CITY OF ALBUQUERQUE

RE: Loma Alegre Subdivision
TRACTS 473 AND 474, UNIT 7, TOWN OF ATRISCO GRANT
Grading and Drainage Plan
Engineer's Stamp Date: 6/8/22
Hydrology File: L10D033

Based upon the information provided in your submittal received 10/25/22, the Grading & Drainage Plan **is not** approved for Grading Permit. The following comments need to be addressed for approval of the above referenced project:

LOMA ALEGRE SUBDIVISION
GRADING PLAN

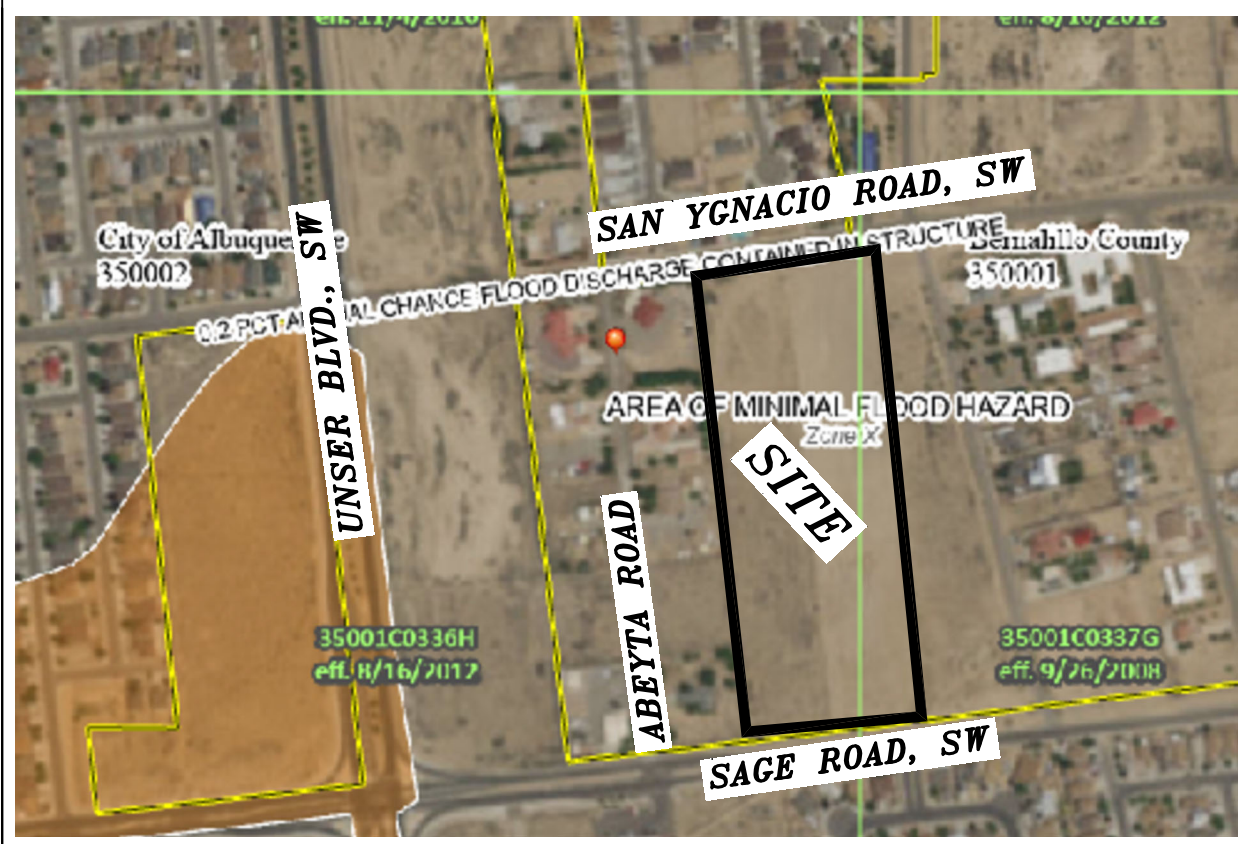
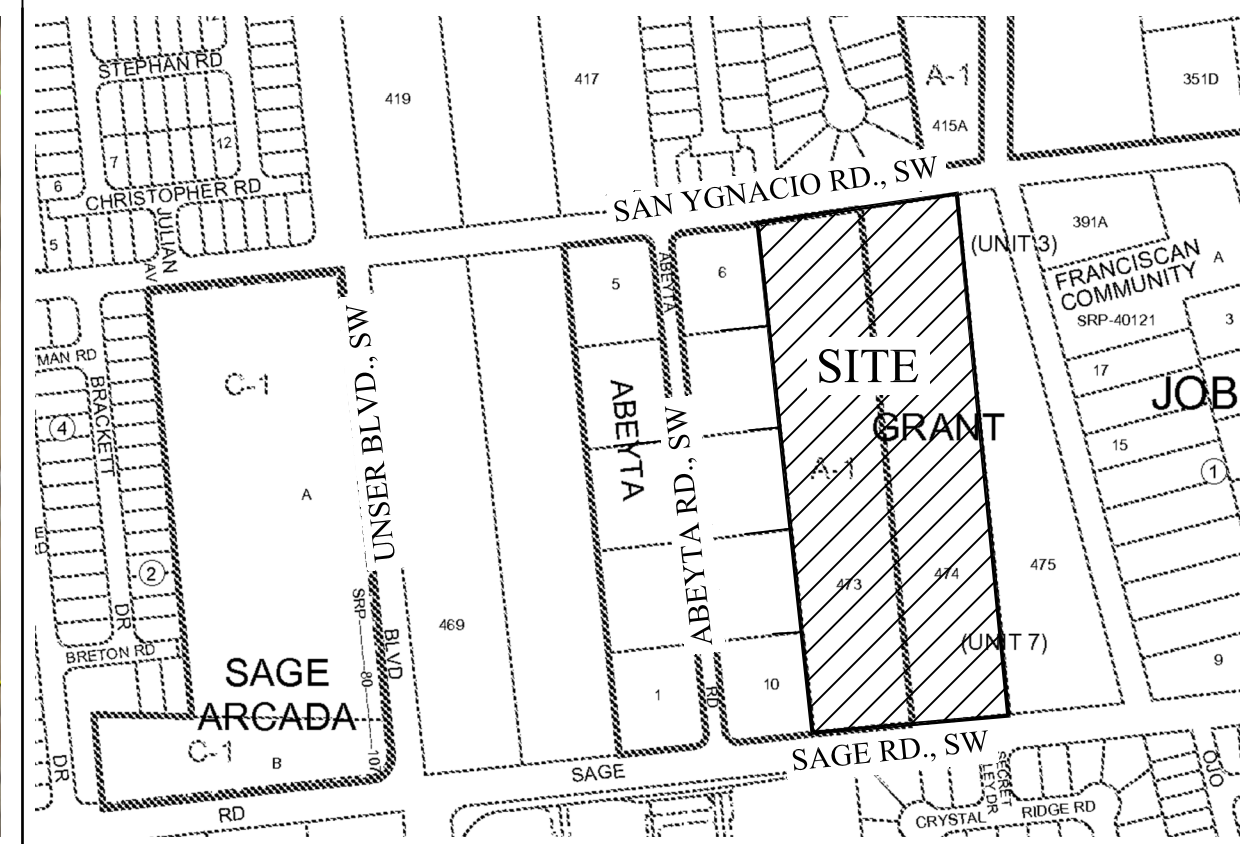
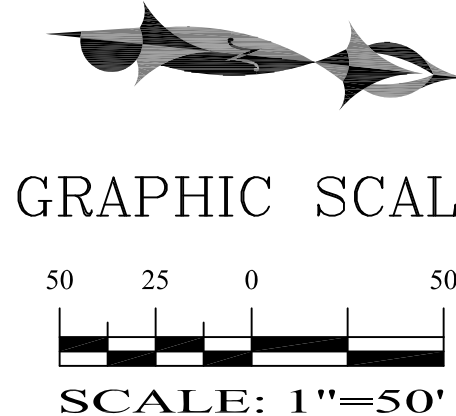
1. Please insert north arrow.
2. Include project benchmark and datum.
3. Include drainage calculations for lots 1 through 8 and 17 through 21.
4. Change Tract 476 to 473 under "Location".
5. Correct a typo of "Are" in the "Area @ the Throat".
6. Verify the Retention Volume Provided = 6,484.70 CF under "Lot 22 – Volume requirements" since the same item listed in the table shows 6,824.35 CF.
7. Add cross-sectional details for Loma Alegre Road, Sandia Sunrise Ct and Zia Valley Ct. Add more FL and TC elevations for all three proposed roads.
8. Drainage covenants will be required.
